Subject: FW: AB/63/20/DOC 74-76 Canada Road, Arundel, West Sussex BN18 9HY - Planning Extension of Time

Condition 4 – Construction Plant and Materials

Condition 8 - Access

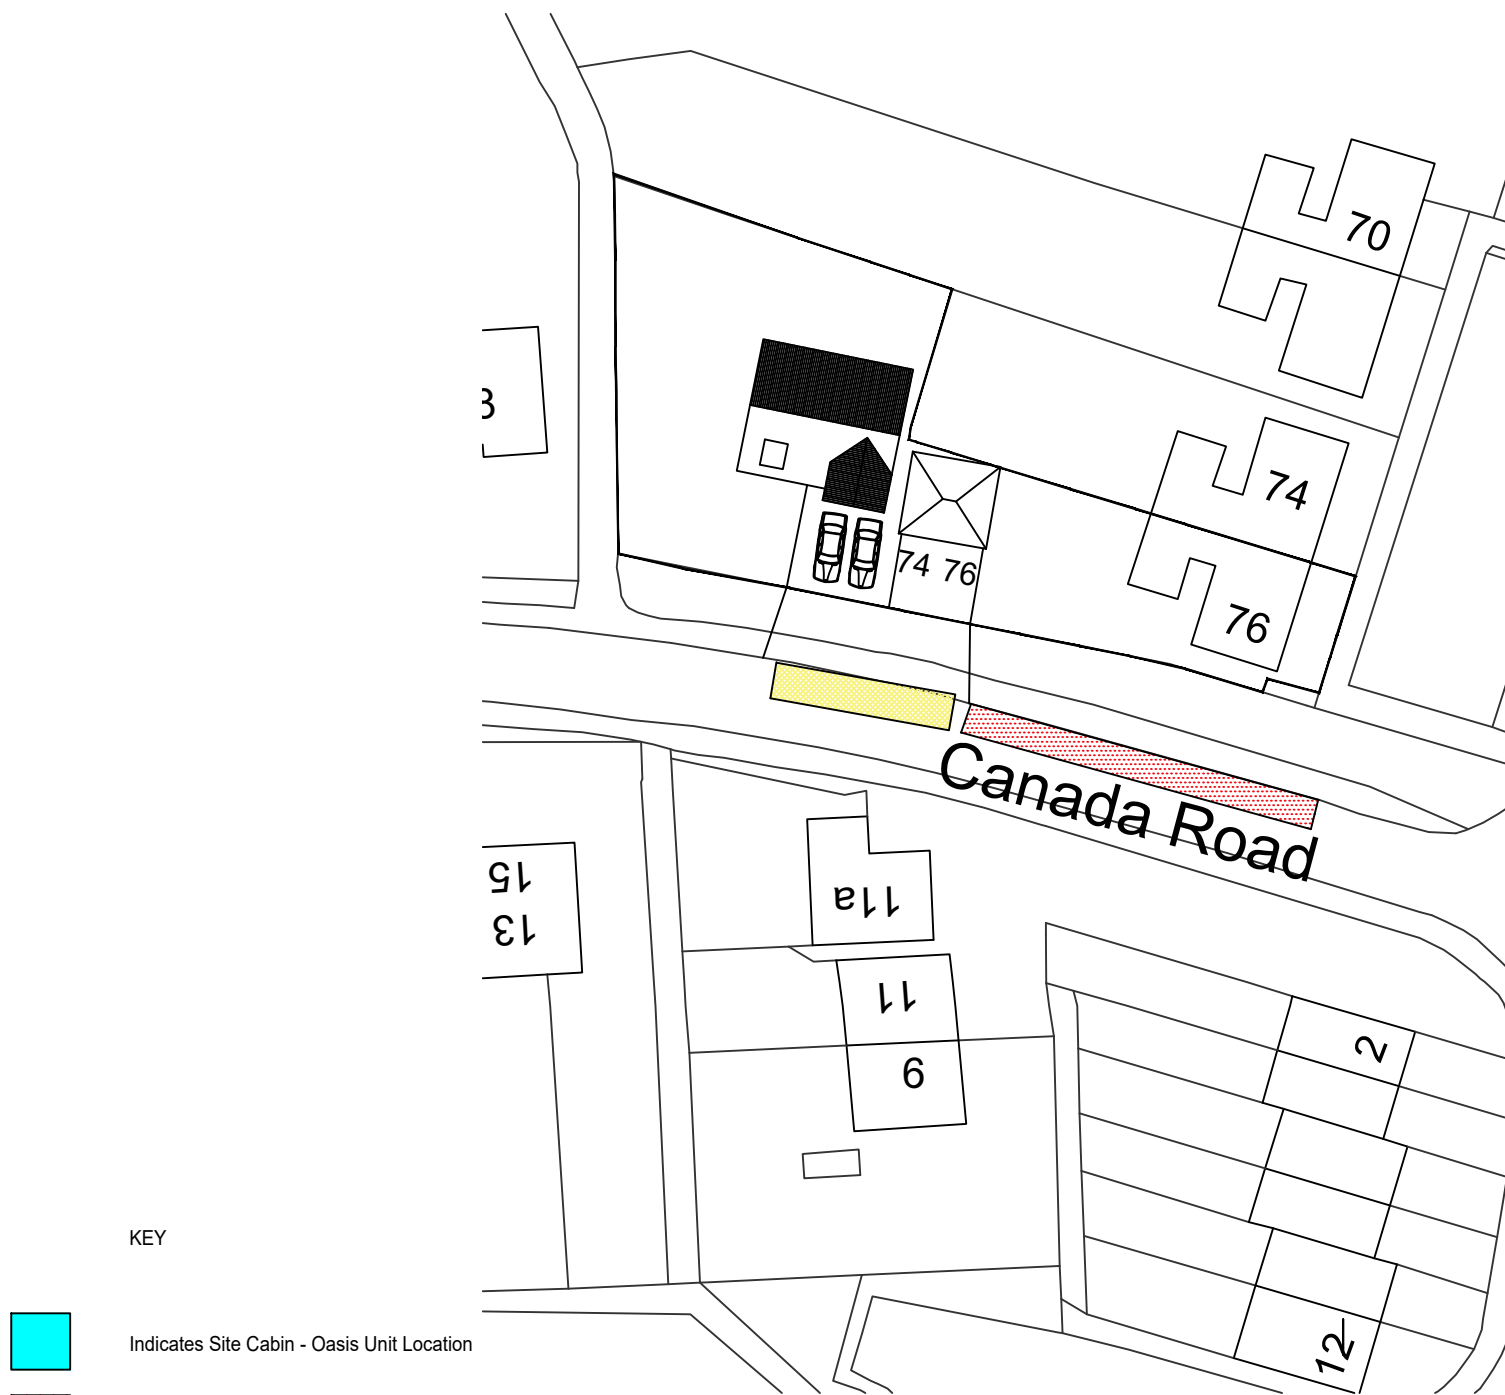
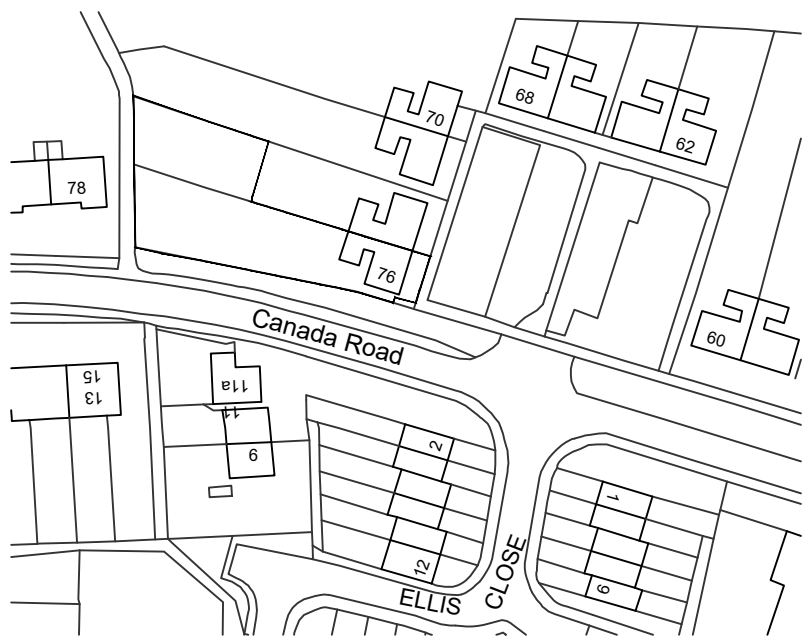
As per, and adding to Stephens comments 30th July WSCC. Parking by contractors can naturally take place on street while taking into consideration any existing traffic regulation orders. However it is not advised that a specific area for this is marked on discharge of condition plan. This is because the roads status as public highway is secured by statute and thus should be free for use by all. It would also restrict contractors to only parking in those specific locations when they may not be free.

This could be mitigated by way of a temporary traffic regulation order, but the applicant does not seem to be proposing this.

It would be better if a statement was made similar to “Due to the constraints of the site contractors will be required to park on street in a safe and considerate location. Any such parking must take into consideration any existing traffic regulation orders.

Similarly with materials storage, typically we try and avoid this if possible but it can be permitted with the appropriate licence agreement from WSCC Highways. Please can the applicant confirm if they do wish to store materials on the highway and I will enquire with the area office if ‘in principle’ such a licence would be forthcoming in such a location.

Drawing No.	Status
15718-HOP-ZZ-XX-DR-C-10008	S0 P3

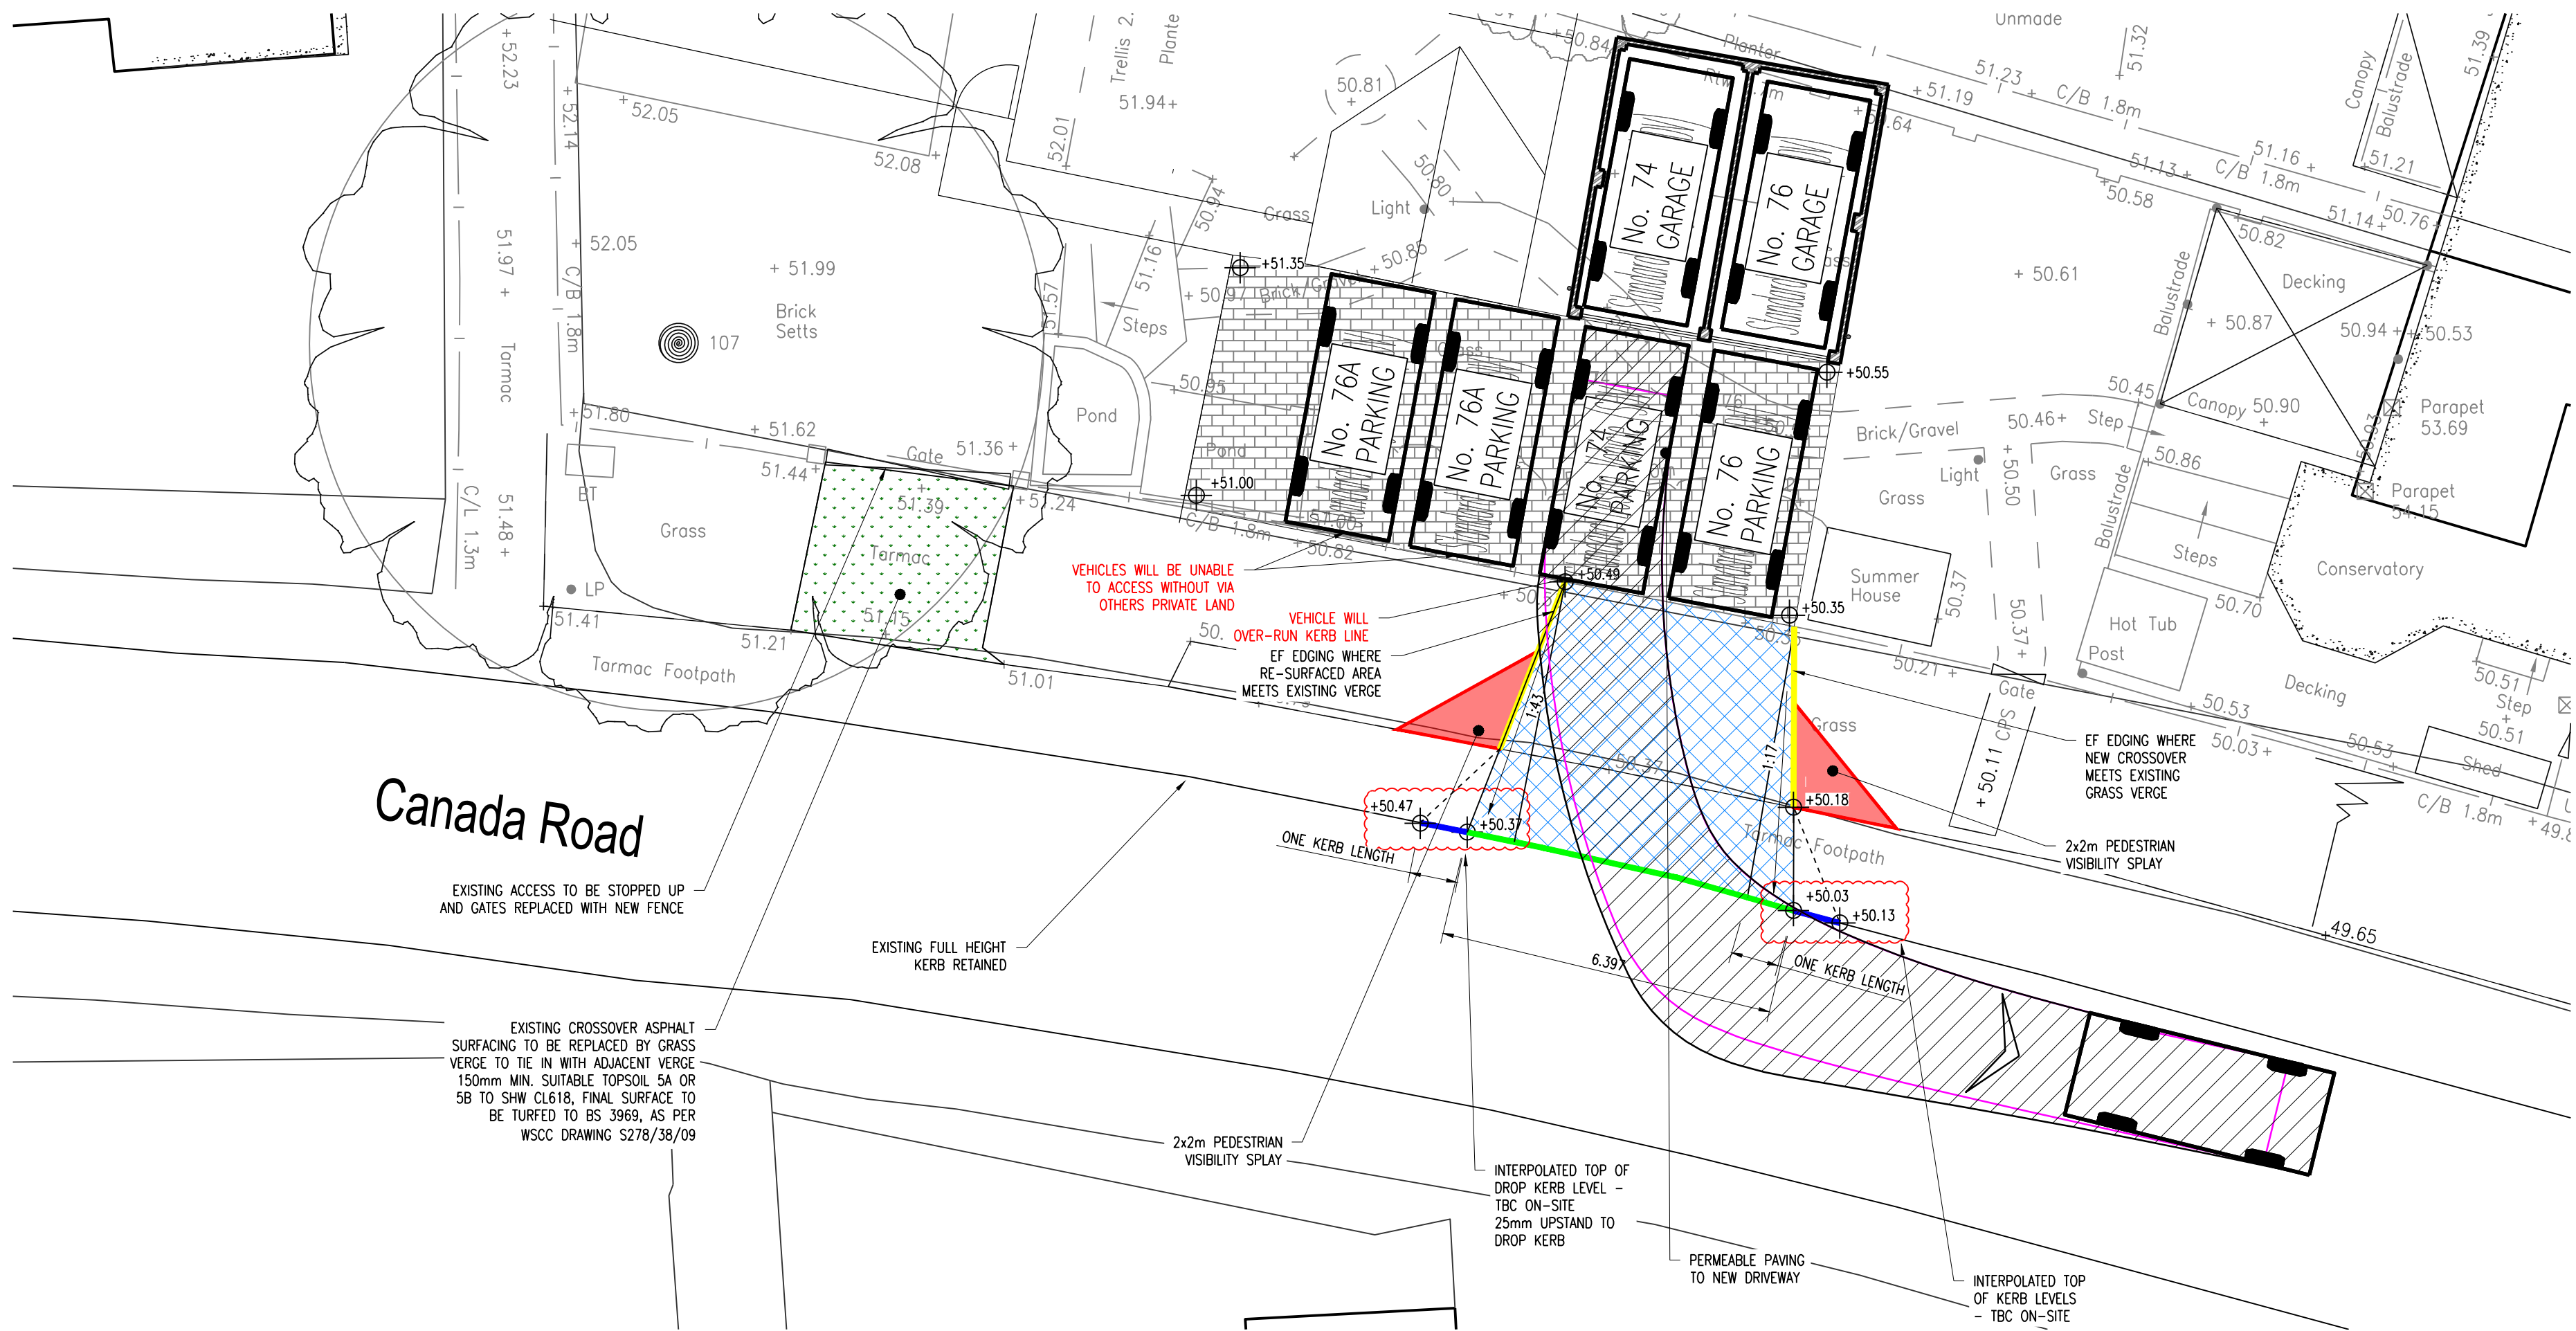
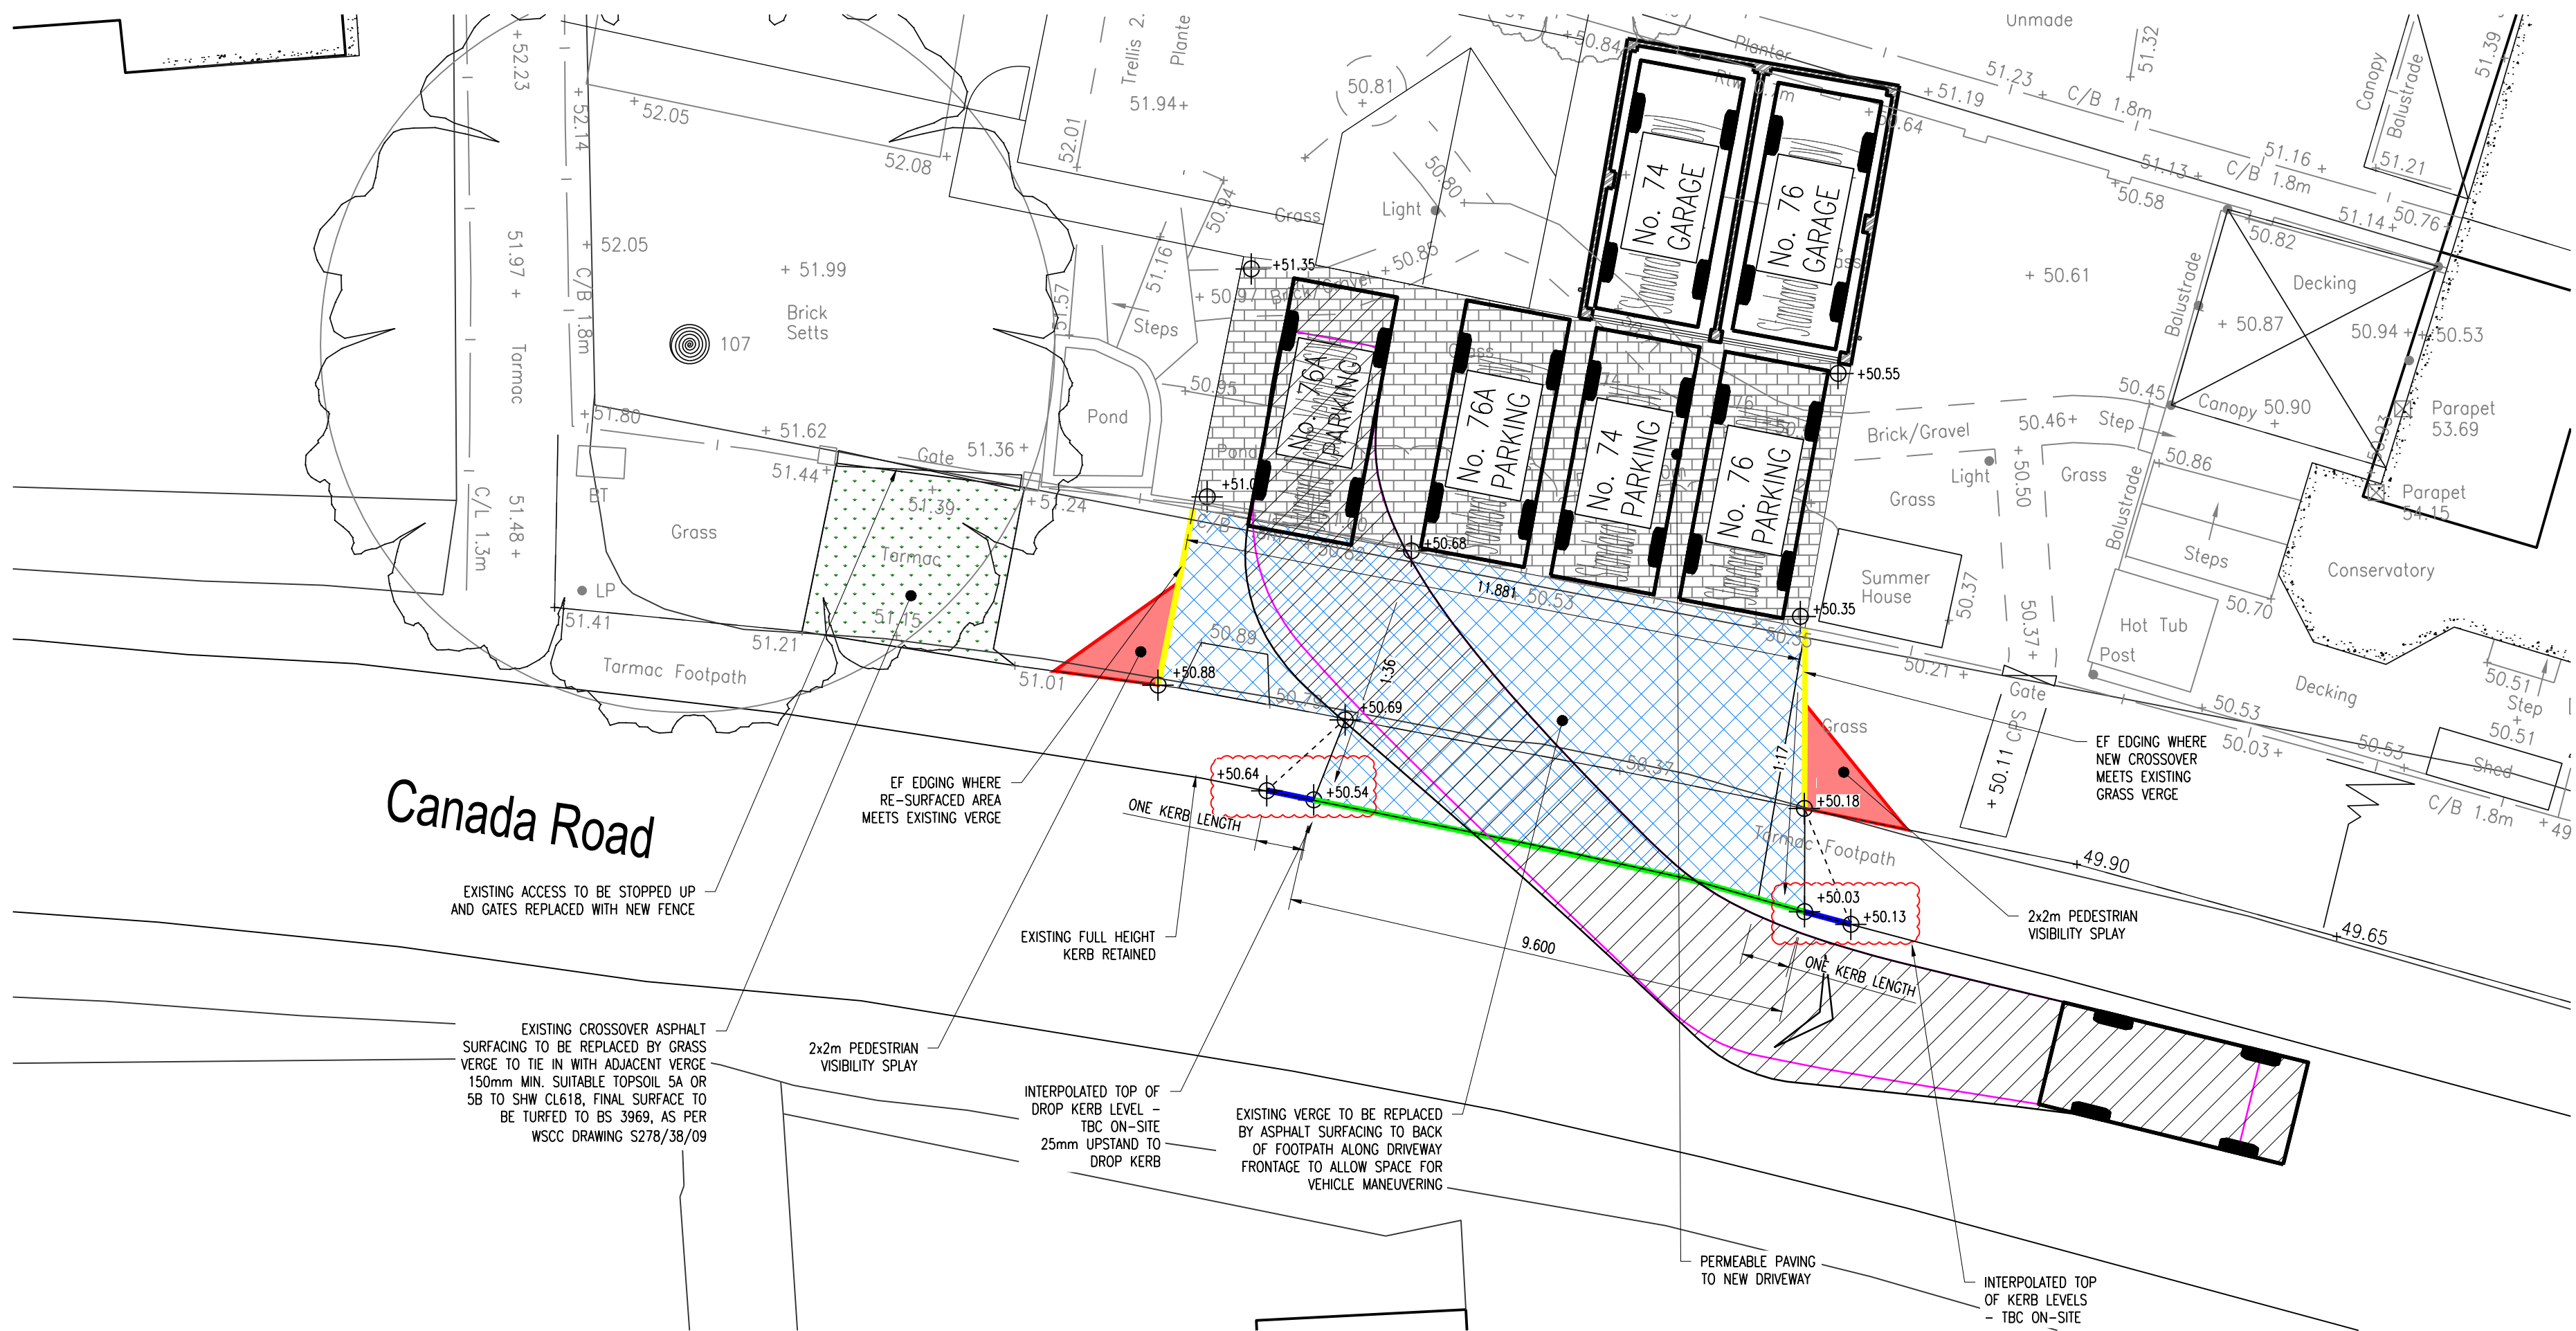
Am I right in thinking they have not submitted any plans that show a reduced width crossover at 6.4m wide? I can’t see such plans on the Arun Planning Portal or on the email string. The latest seems to be Plan 101A as attached to one of Glenns emails.

Glenn seems to be asking if a crossover width of 9.6 metres would be acceptable. I can see the logic behind this as it would allow for convenient access to the garage spaces and hardstanding for 74 and 76 Canada Road and allow for access to the proposed parking spaces for the new dwelling. To my mind a 6.4m wide crossover may limit accessibility for some of the spaces, though its difficult to say this with any certainty as that has not been demonstrated to date.

Our area office are resistant in granting licence application grater than 6.4 metres in width due to the loss of on street car parking provision. I think the only way forward is to present to the area office a plan that shows how a 6.4m wide crossover is not workable. I.e. showing a 6.4 crossover where it is then clear that vehicles accessing the new parking spaces will be required to bump the kerb in order to access the approved parking spaces. A similar plan showing a 9.6 metre wide crossover or greater can then be provided to show the minimum width required to provide a workable solution. This will then be materially different to what we have presented to the area office with to date to provide us a view on.
